Ref: MIDA3001

**FORMER ESSO GARAGE, BATH ROAD – APPLICATION FOR APPROVAL OF NON-MATERIAL AMMENDMENTS IN RESPECT OF PLANNING PERMISSION 18/04620/F**

On behalf of our client **Mid Group**, please find enclosed a non-material amendment ['NMA'] application (made under Section 96a of the Town and Country Planning Act 1990) in respect of various changes to Planning Permission **18/0460/F**, which relates to the former **Esso Garage site on Bath Road** ['the Site'], and the comprehensive redevelopment to provide 152 new homes and associated development ['the development'].

Site Elevation 04
Block A - East

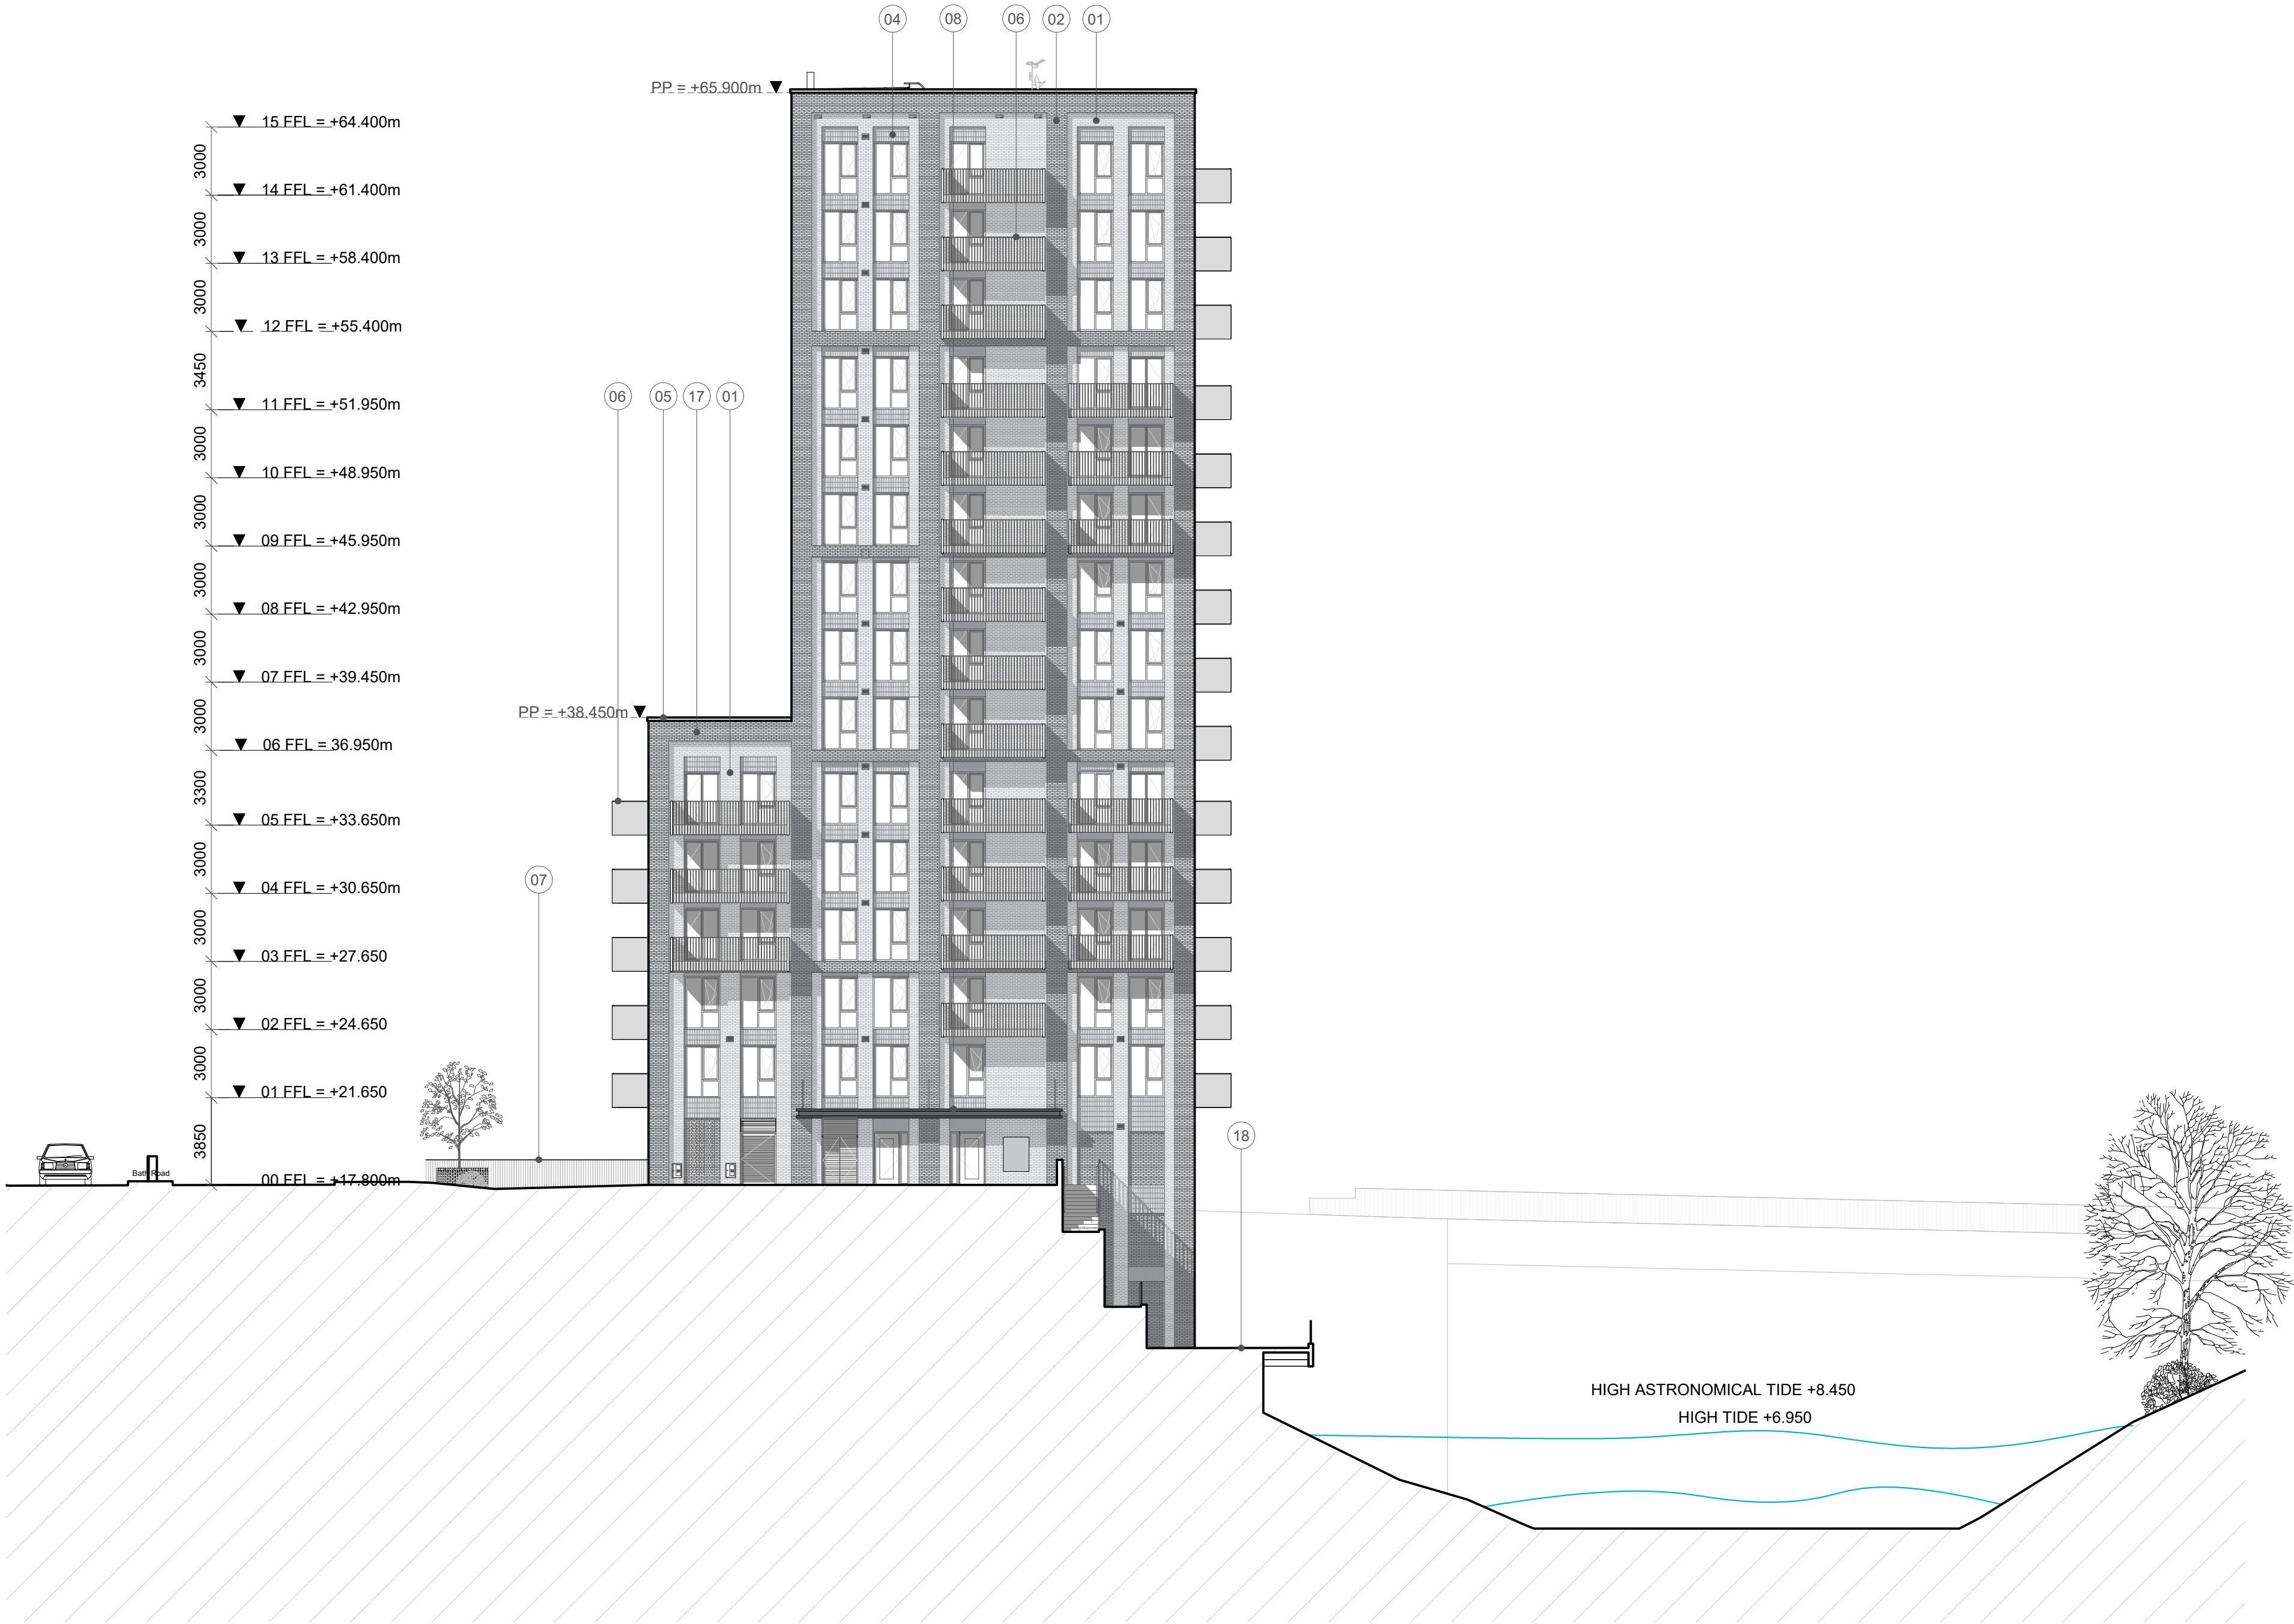
- (a) External lift omitted from adjacent to Block A and now included within Block A – giving a direct access to the river. External stair reconfigured;

*- As a result of EA access requirements and to provide a more secure lift for use within the building this is now within the Block A envelope and a dedicated new entrance has been formed for this.*

- (e) Amendment to South elevation of Block A windows (windows to riser and stair omitted) and windows to bedrooms narrowed symmetrically;  
*- Windows shown in service riser on approved planning drawings - elevation re-configured to give impression of symmetry without needing to glaze flue riser.*

- (f) Heights of Block A amended – lowered by 1350mm;  
*- Design development to allow level access to amenity terraces*
- (g) L00 to L01 Block D lowered by 1440mm;  
*- Height shown in planning did not work with compliant staircase due to slope in existing topography*

- (h) Position of Block A adjusted by 660mm (moved away from boundary) to keep sufficient distance from highway retaining wall and avoid oversailing balconies over boundary;  
*- Ownership boundary not shown on planning drawings, adjusted to suit;*

- (i) Change of PPC spandrel panels to glazed brick on Block A to follow panels on other block;  
*- Construction system choice to allow safe construction methods and longevity of detailing.*
